ATTACHMENT 2 (A)

Newcastle City Council (NCC) letter 19th October 2017

Document Reference No.: 14002

Project
ELGAS STORAGE FACILITY
Part Lot 1 DP 1145444 - CORMORANT ROAD Cnr. EGRET STREET
KOORAGANG NSW
FOR
SOVECHLES NOMINEES Pty Ltd
Drawing Title
LANDSCAPE SITE PLAN

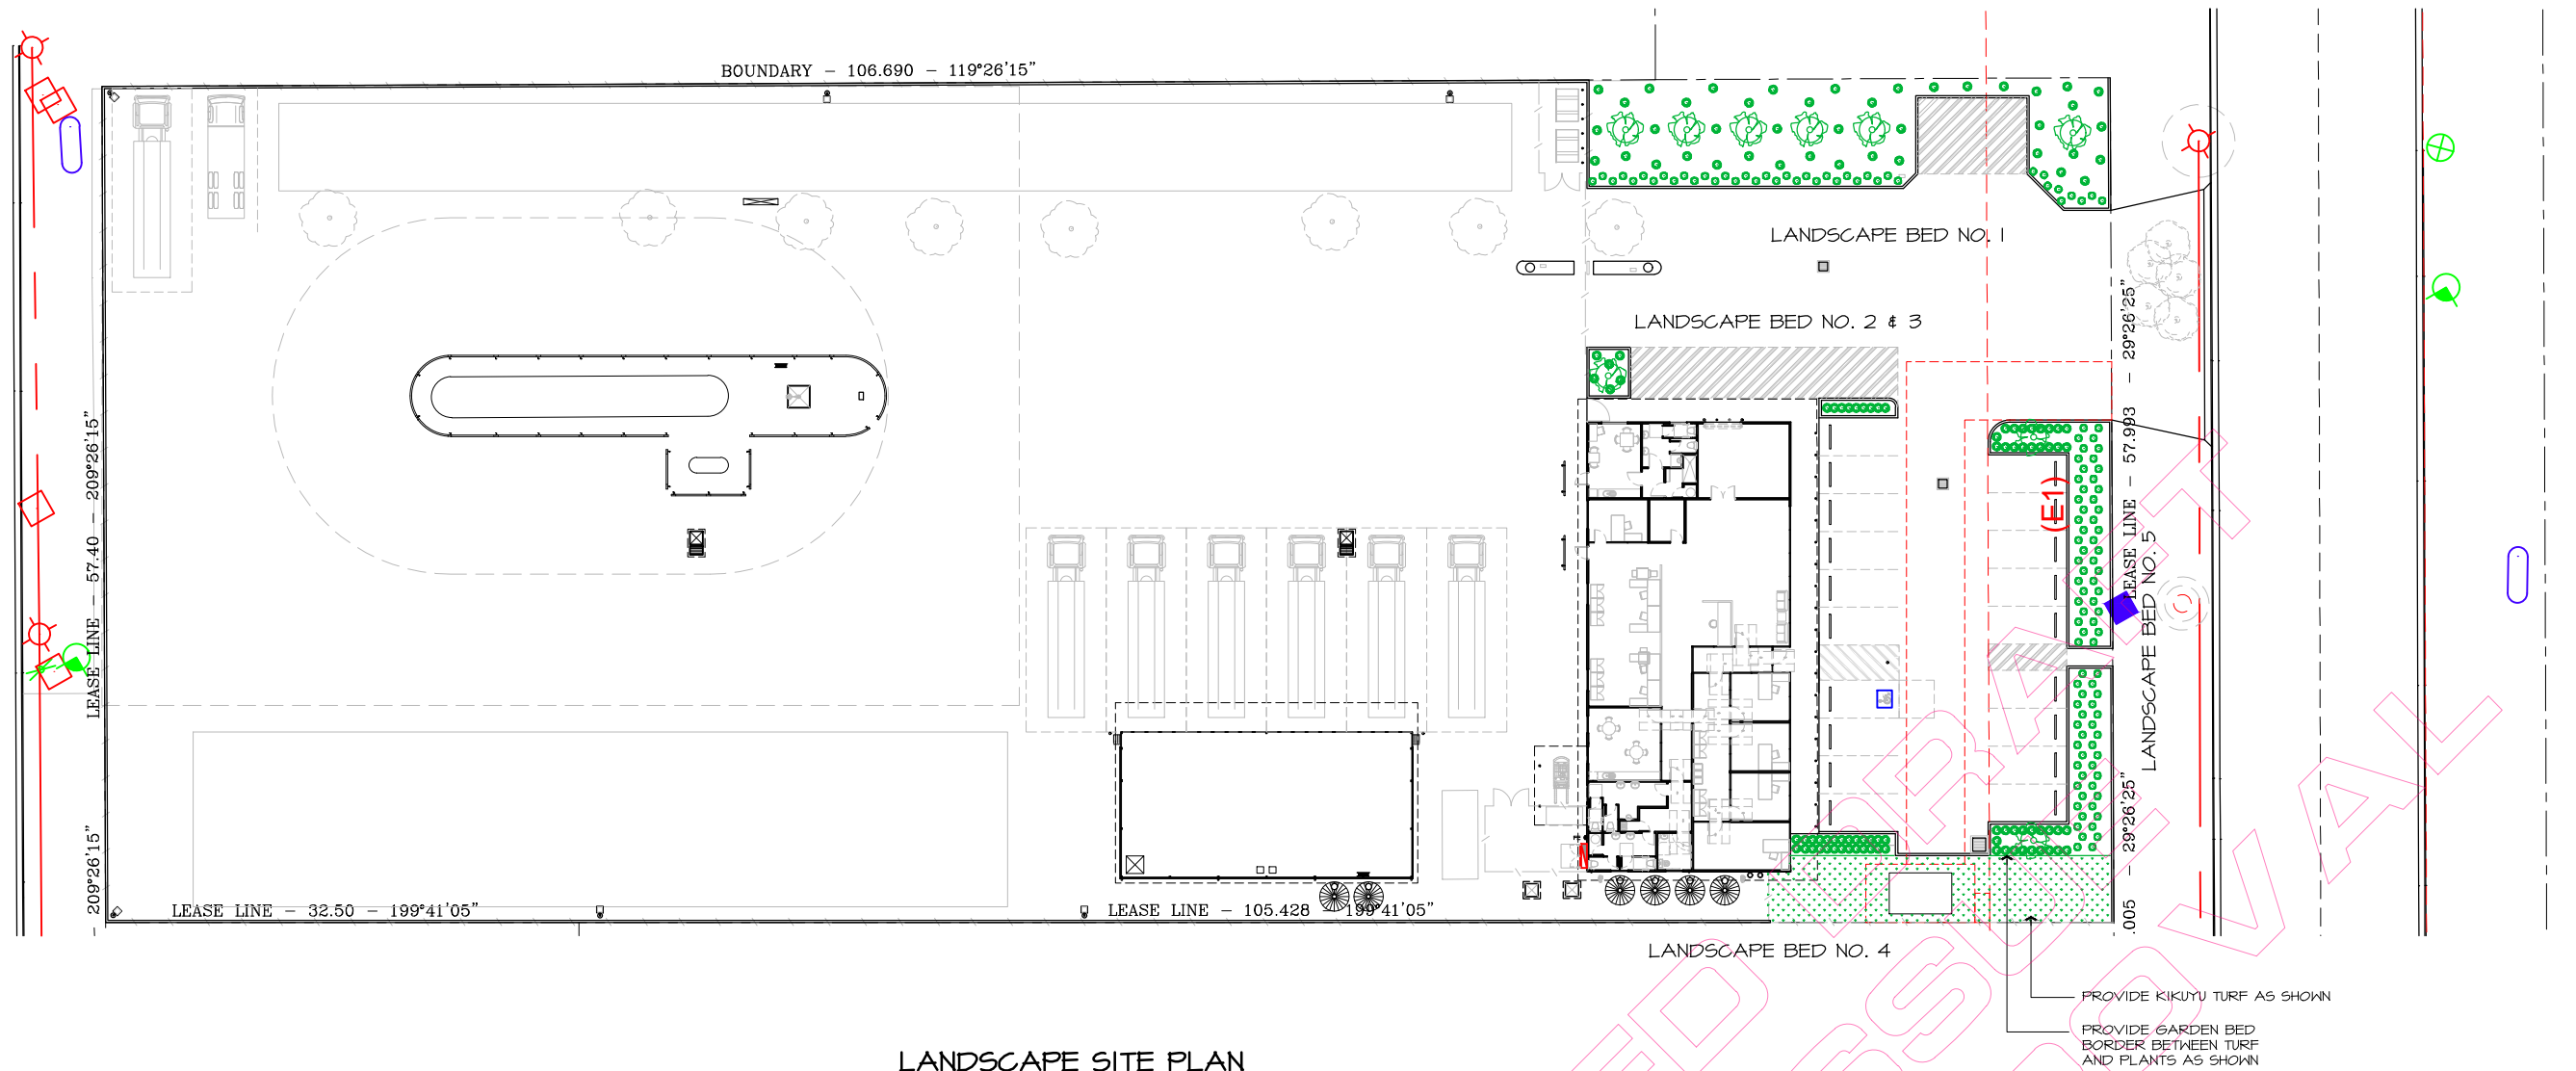
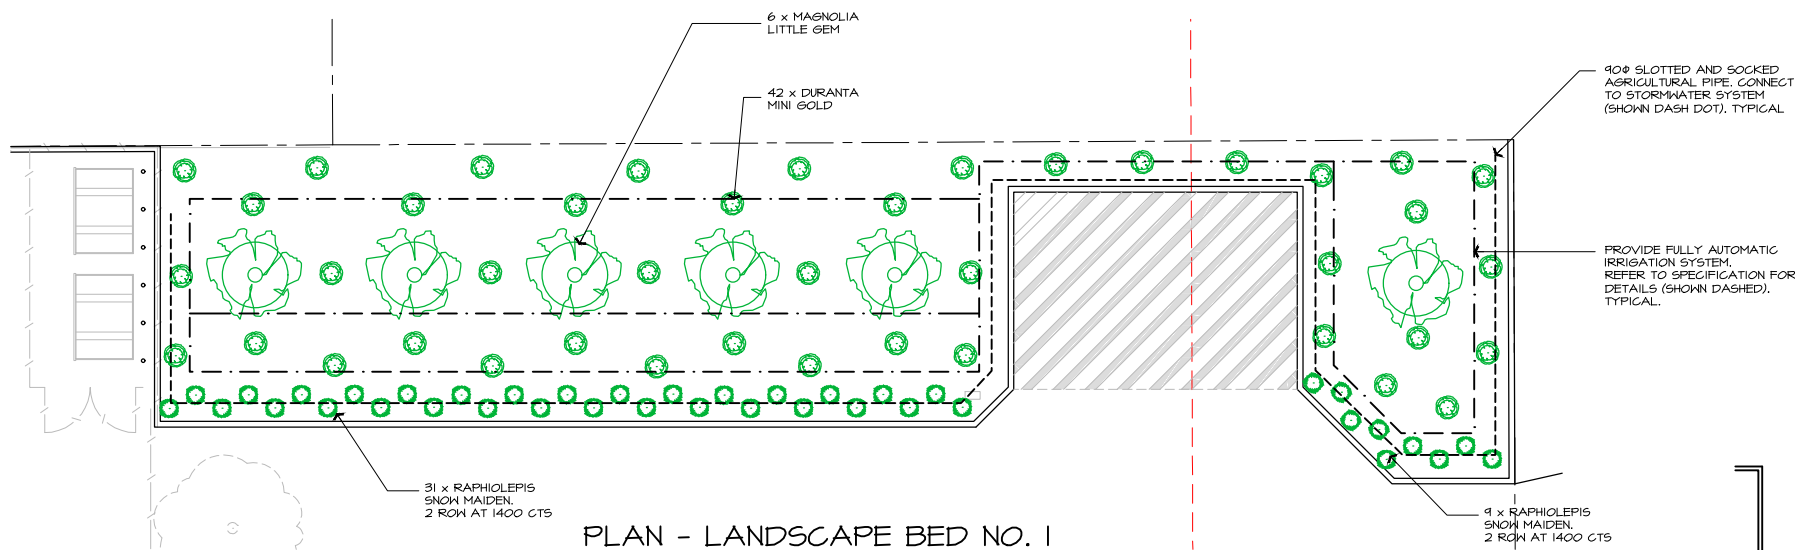
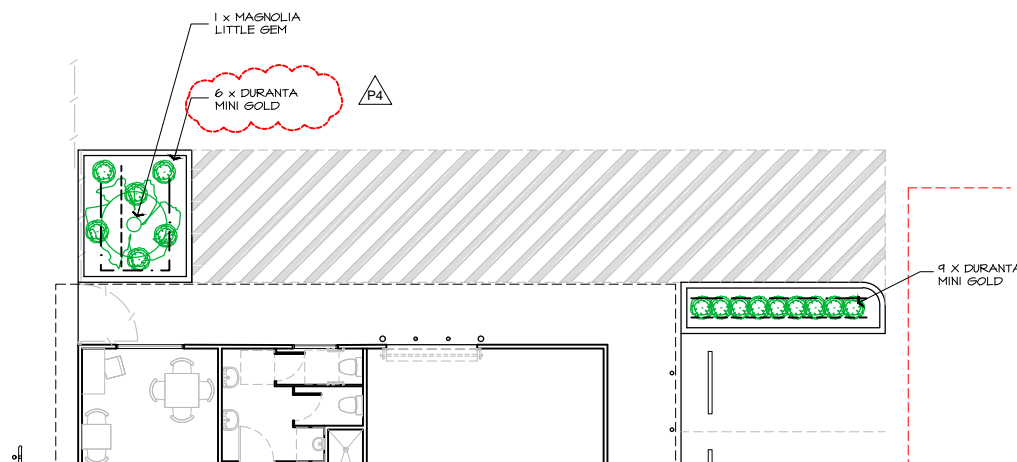
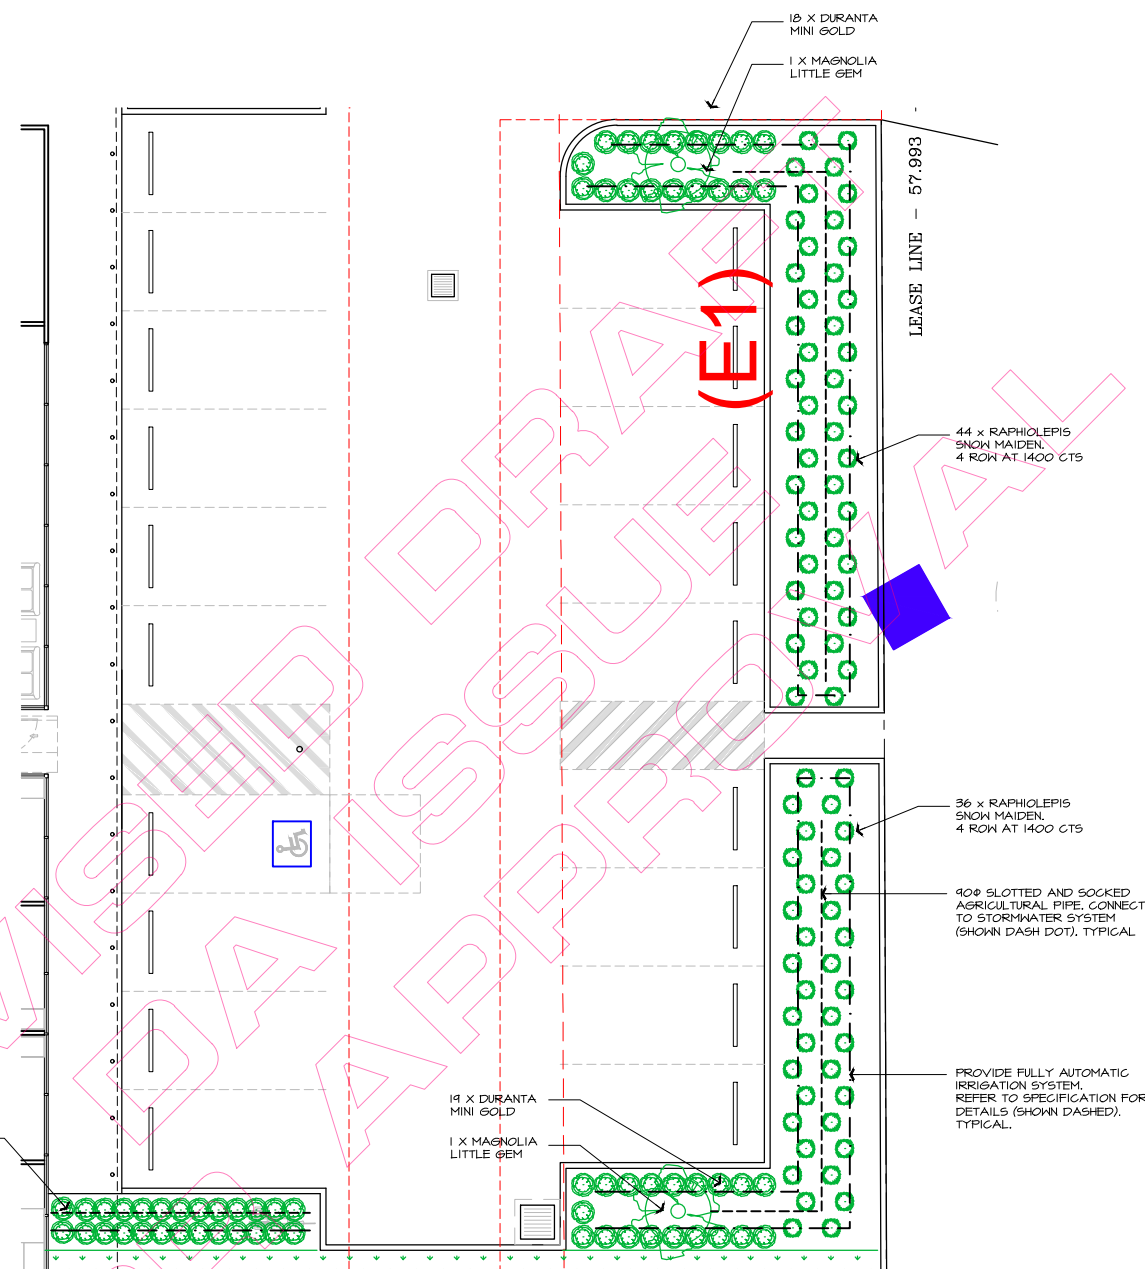
The selection of plant species for the landscape beds is unsuitable for Kooragang and the plant species should be low maintenance, drought and salt tolerant and be native and endemic to the area. Furthermore, the mature height and width of the various species should be appropriate to the purpose of the landscaping. For example, generous shade trees should be planted in the parking area at a rate of one shade tree per six parking spaces.

Landscaping: All plants selected are low maintenance and have been selected to cope with being near the coast and have been sourced and supplied by Glendale Select Plants, who are a specialist wholesale nursery supplier in the Newcastle region. The selection of plant species proposed for this offer is the same as what has been used for the previous 2 developments for Lot 1 (service station & car wash). The plantings in these initial stages (that were DA approved) are now already established and coping very well. They have shown to survive and are drought and salt tolerant. The selected plants, ongoing maintenance and up keep give the site very good street appeal.

We can confirm that the landscape design and plant selections are consistent with Stage 1. All plants selected are low maintenance and have been selected to cope with the relevant conditions and the selection of plant species proposed for this stage will very much suit the offer as they have in the 2 previous developments for Lot 1 (service station & car wash).

The plantings in these initial stages (that were DA approved) are now already established and coping very well. They have shown to survive and are drought and salt tolerant and we see no reason to change the proposed design and respectfully request the department to accept the design without further change.
